Land at Bilsham Road, Yapton
Planning Reference: Y/70/22/DOC

Approval of details reserved by condition imposed under ref Y/91/17/OUT relating to Condition Nos 9 - surface water drainage

At this stage we would not recommend that the condition is discharged until further information as outline below is resolved and provided:

Drawing Status	FOR APPROVAL		
Client	THAKEHAM		
Project	BILSHAM ROAD YAPTON		
Drawing Title	S104-CONSTRUCTION DETAILS SHEET 1 OF 2		
Scale	NTS	Date	FEB 22
Drawn By		Checked By	
Drawing No.	D1956-15-100		
Rev.	-

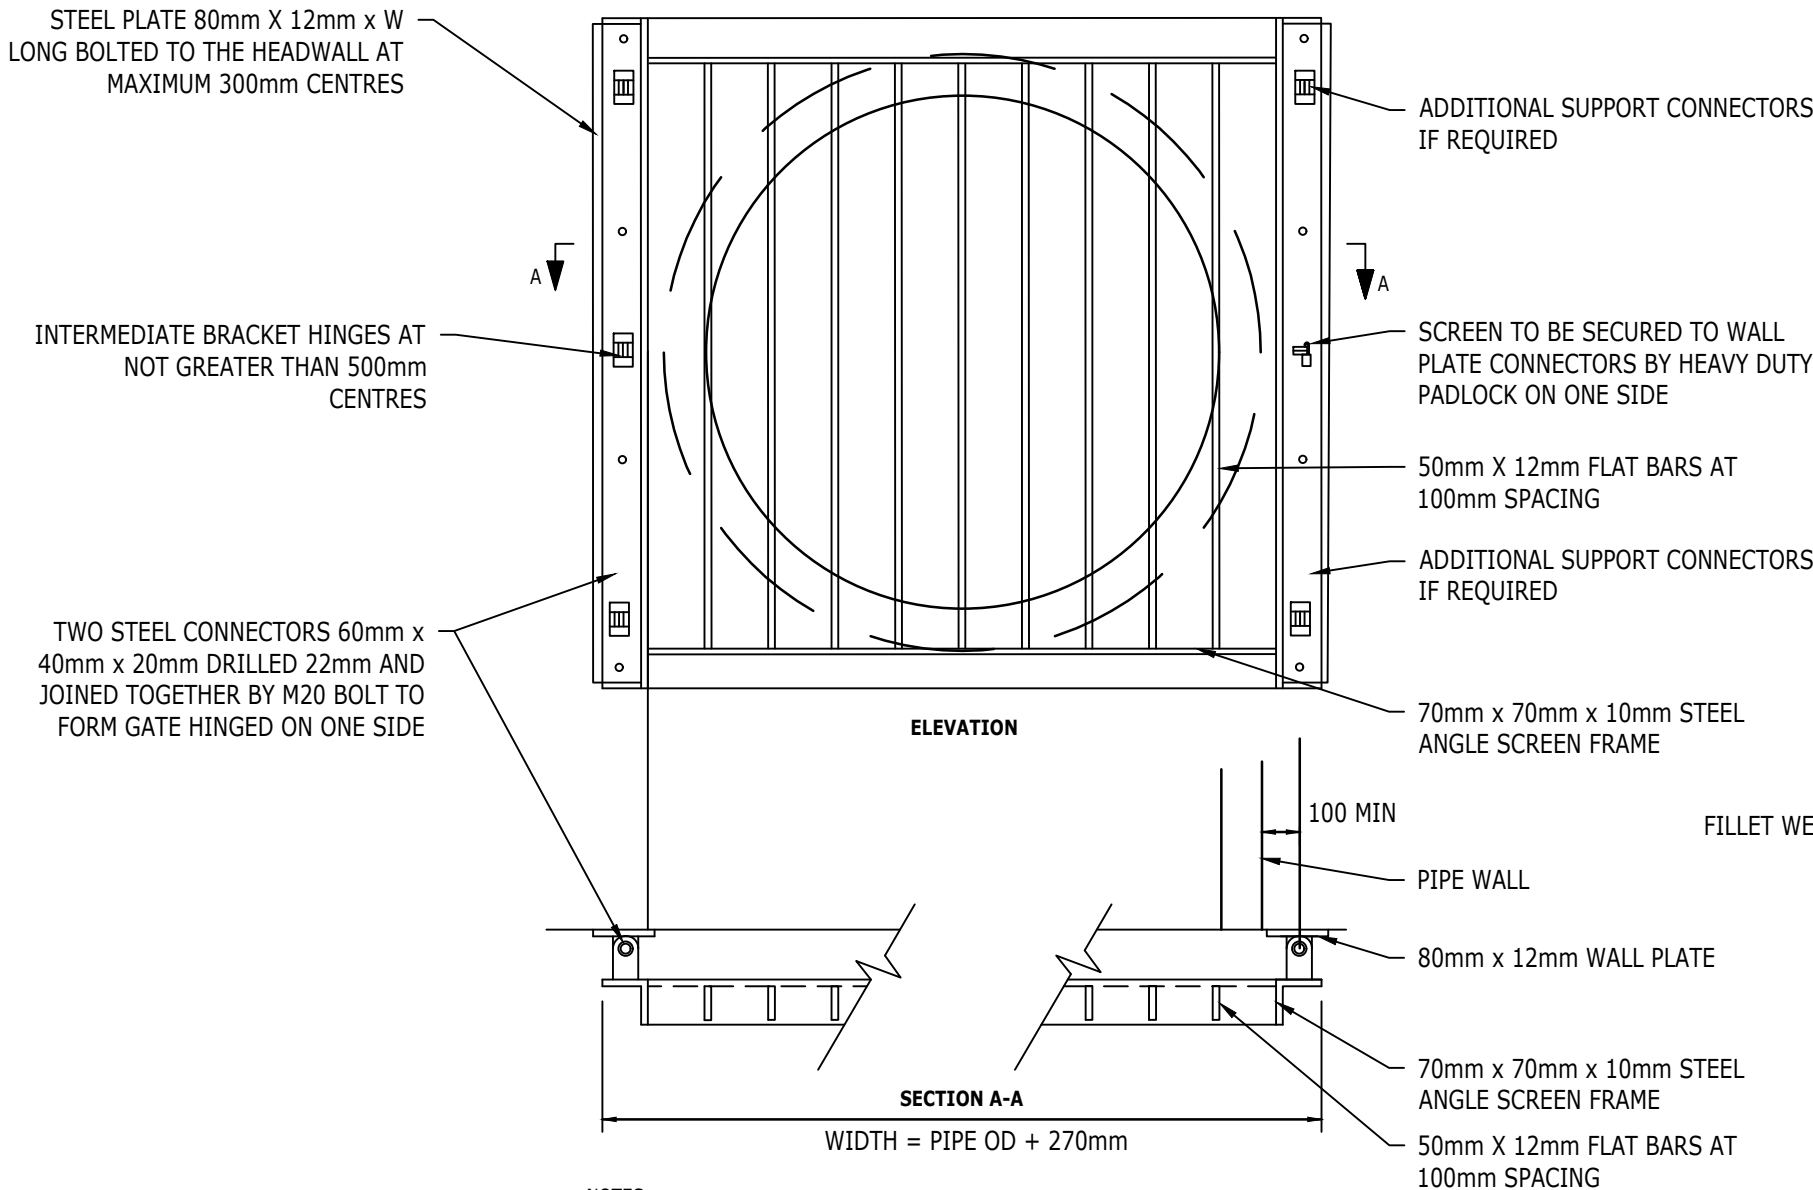
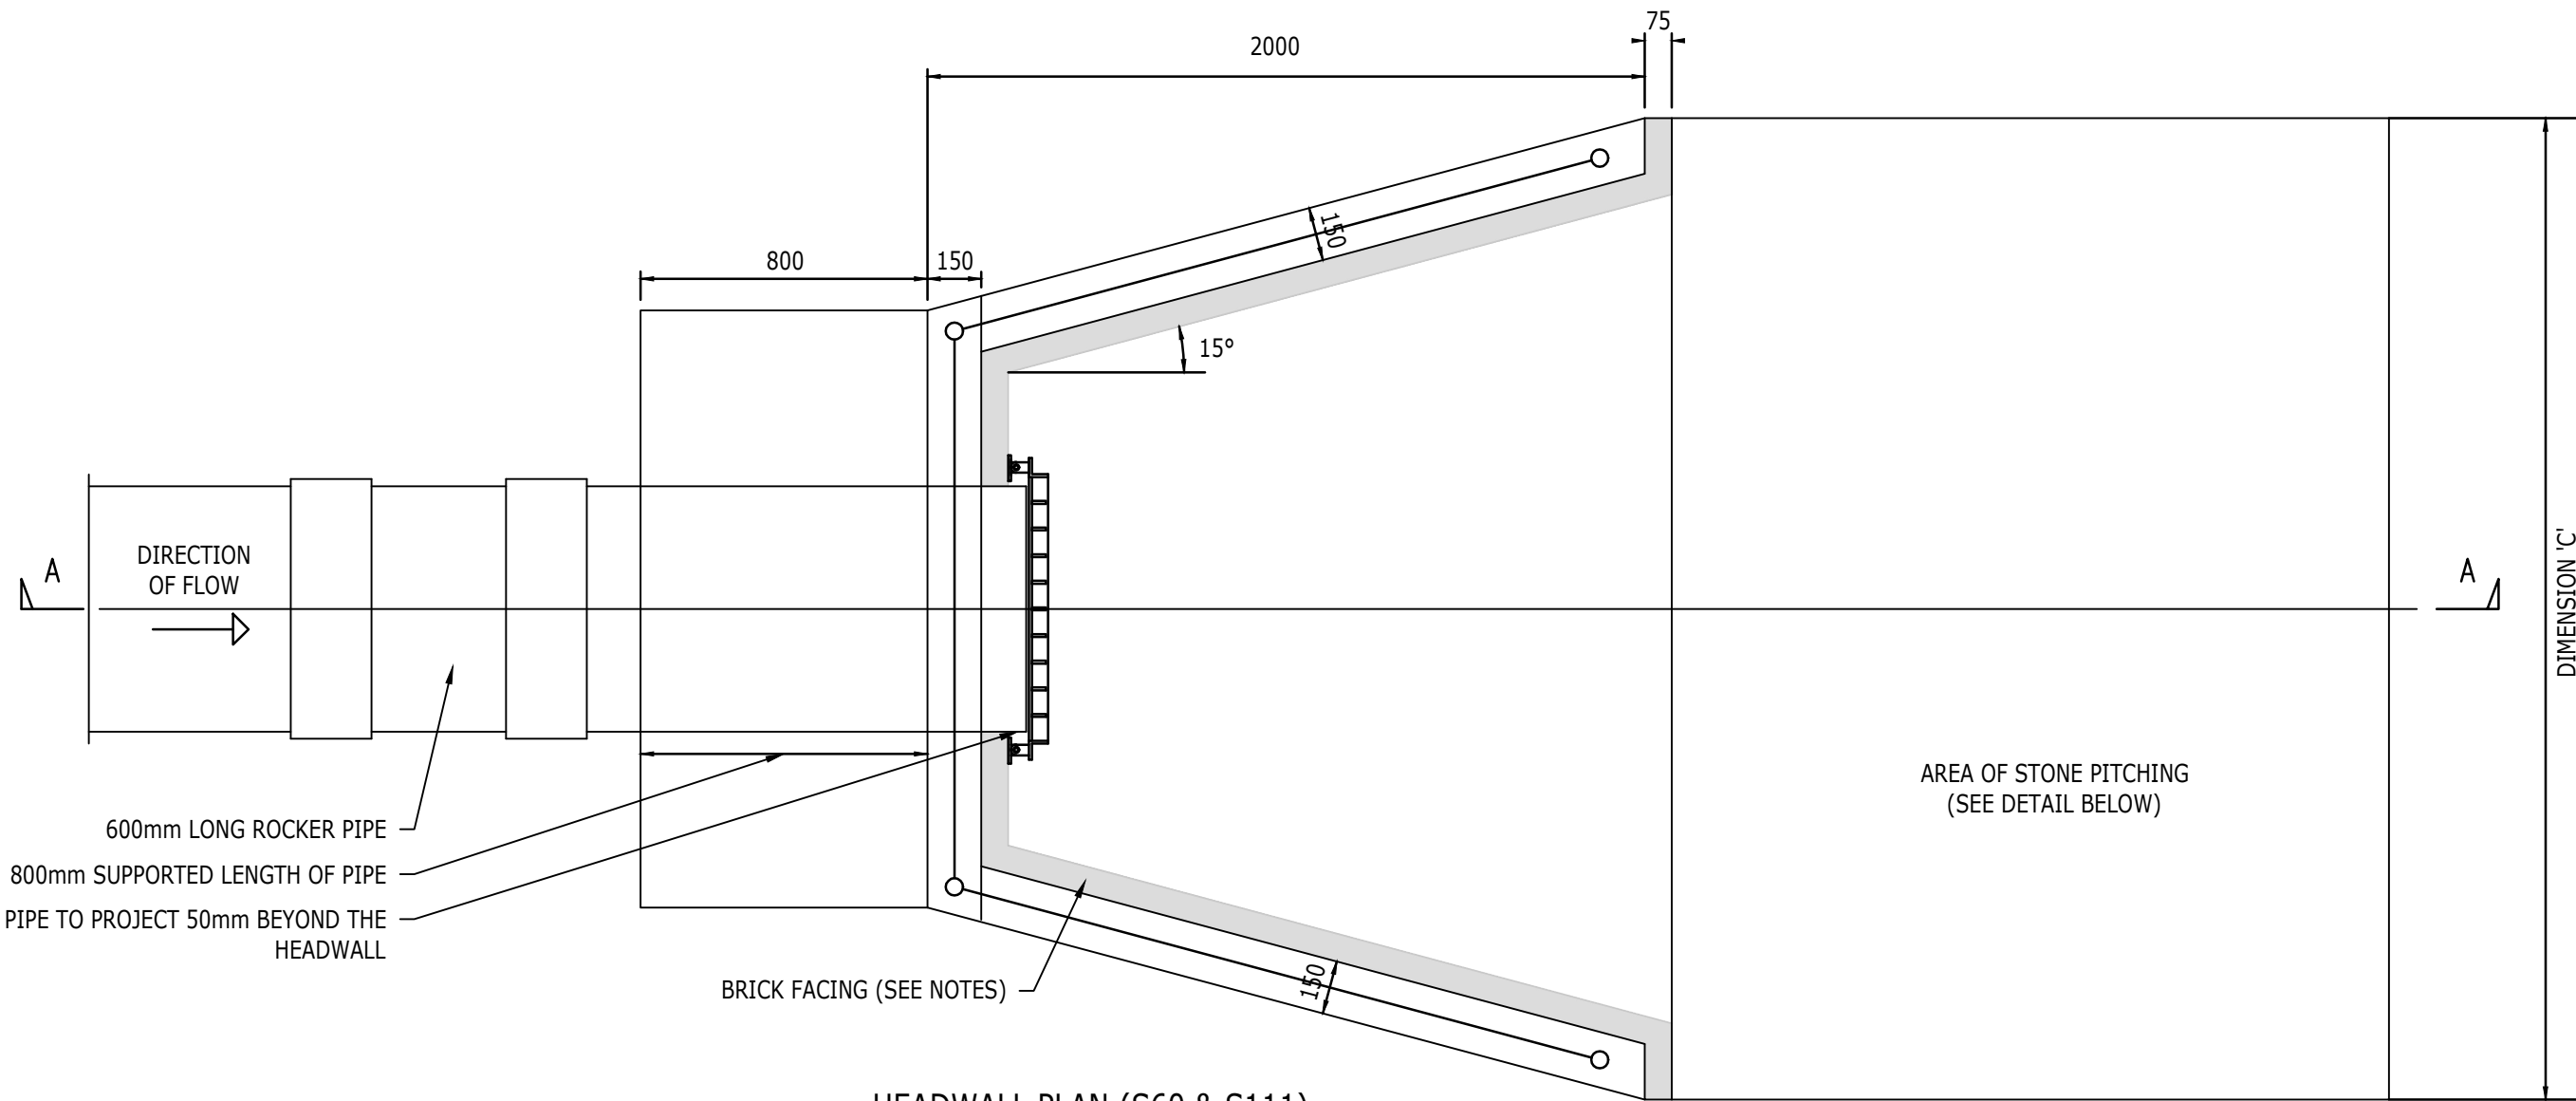
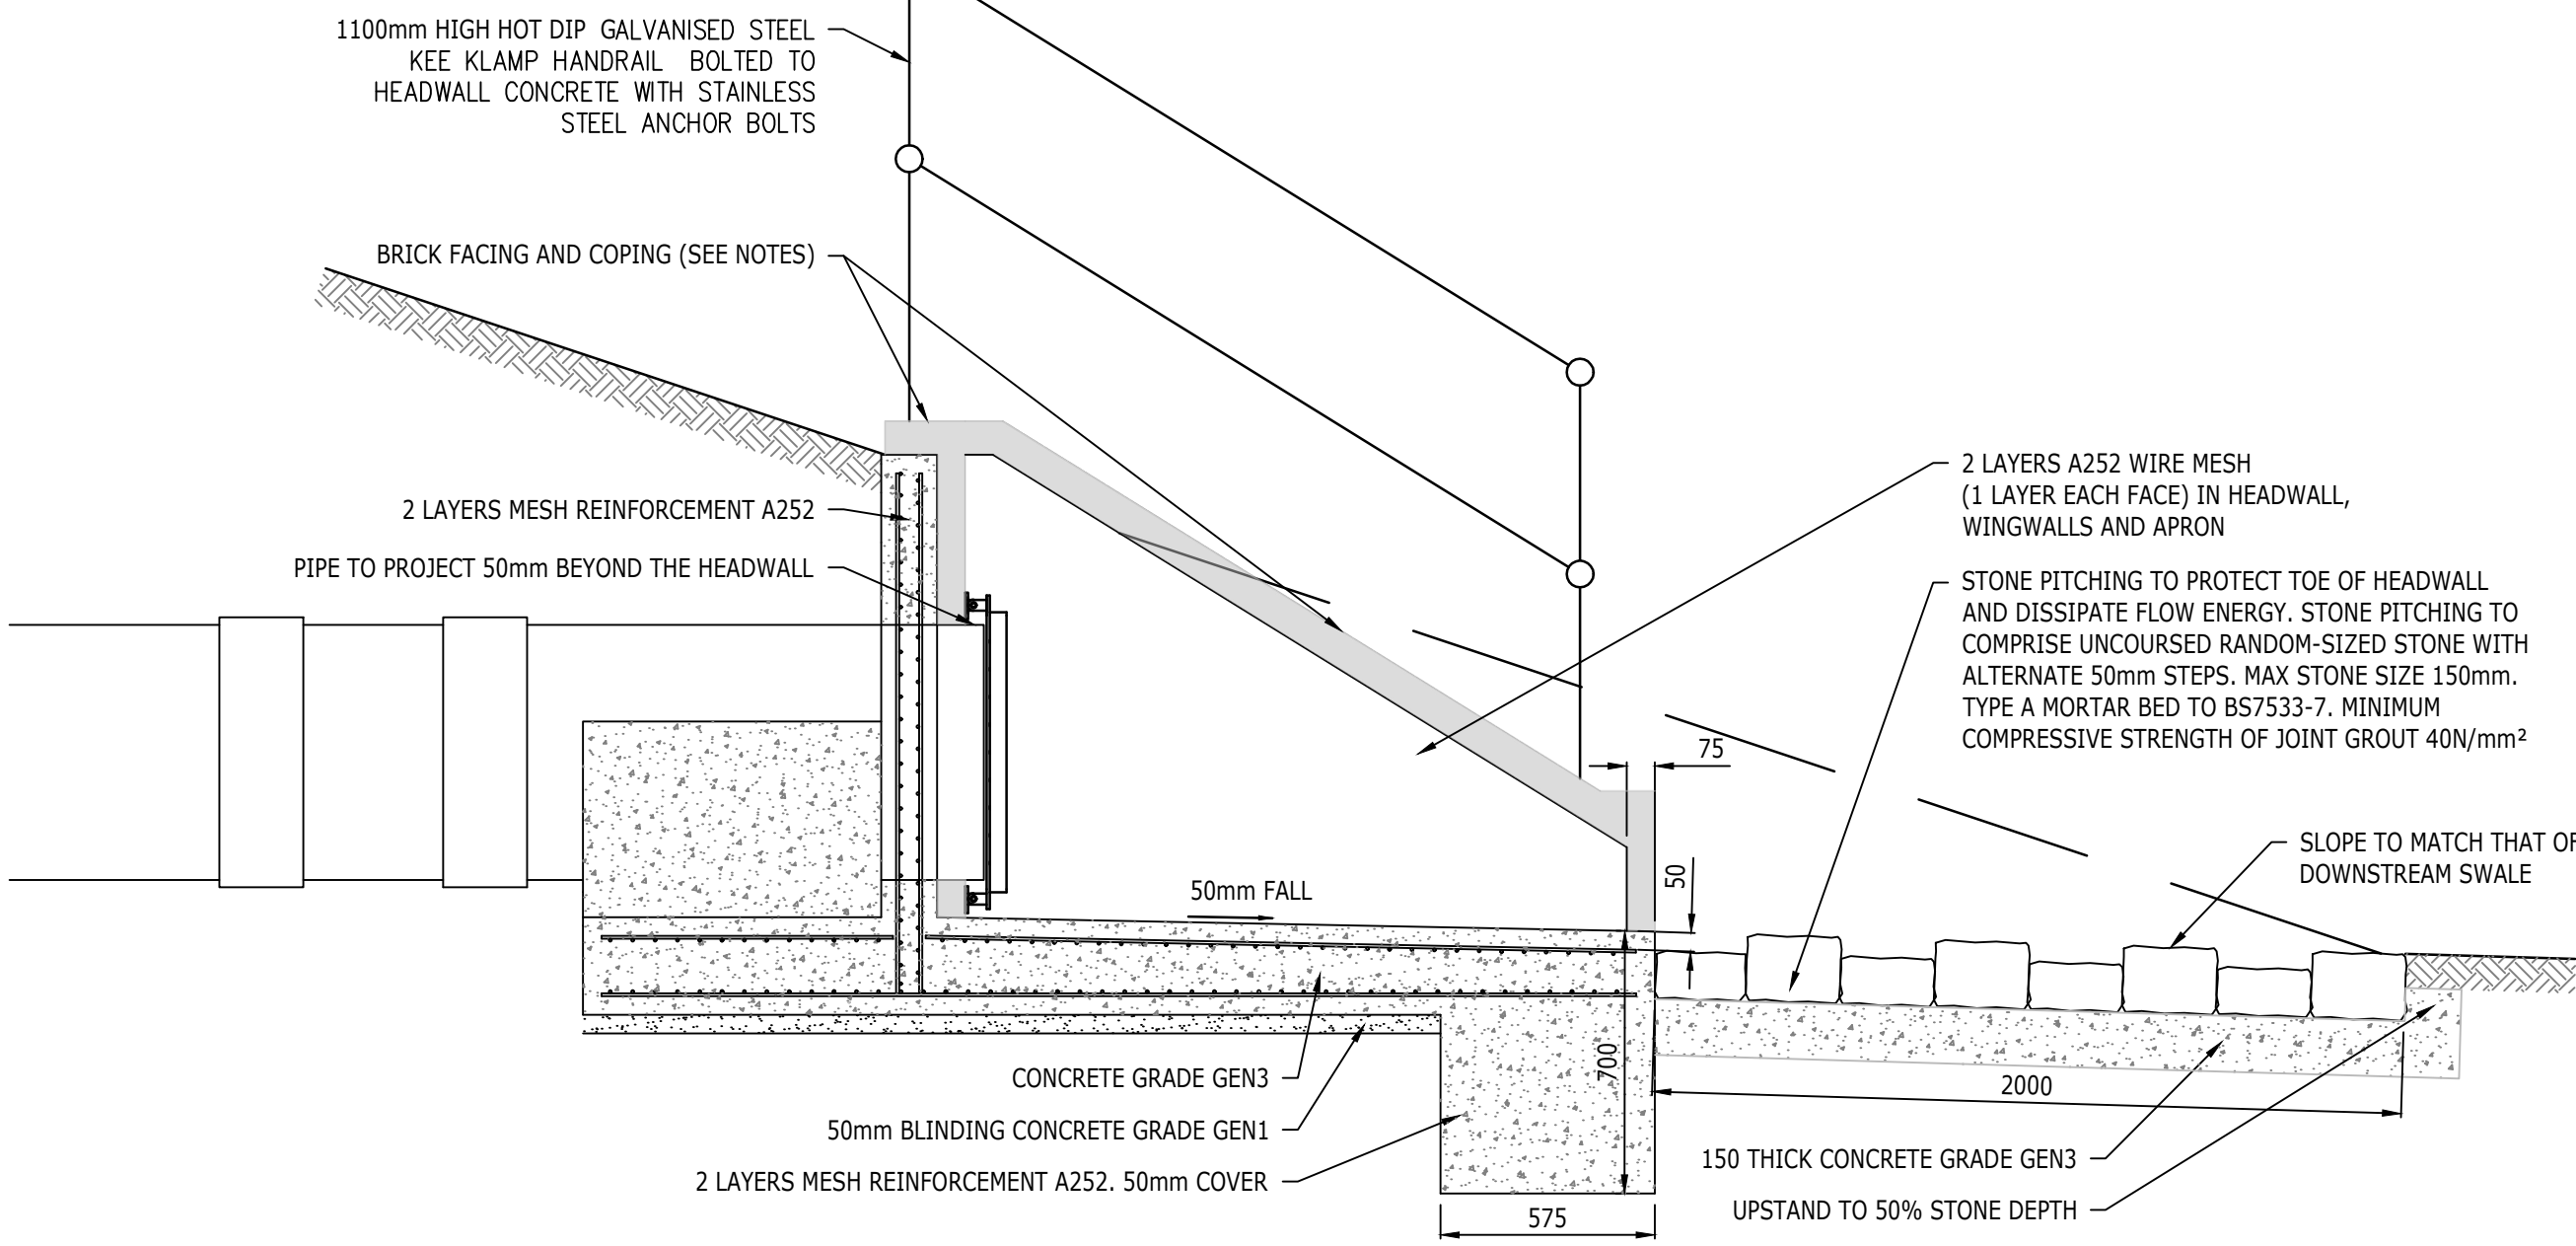
10. *Please detail proposed outfall inverts, along with invert of culvert at the proposed points of connection. Connection should be made soffit to soffit.* Currently not shown on the drawings. The covering letter highlights that this is provided on the details drawing D1956-15-100 which formed part of the previous application, in which case this should be resubmitted with this current application as well for review

11. *Please provide cranked grilles at a 45 degree angle.* - Cranked grilles required on heads – S104 Construction details sheet 1 of 2 D1956-15-100 needs to be updated to suit ADC requirement. Pipe beddings details on this drawing are illegible in parts. Information needs to be clearly presented. We note that applicant’s response that this is not “DSG compliant” however the drawings refer to Sewers for Adoption 7th Edition. As such the applicant needs to be clear which edition of Sewer for Adoption the adoptable drainage is being designed to. In addition they should confirm who the adopting authority will be as well as confirmation from the adopting authority on whether they will or will not accept cranked grilles.
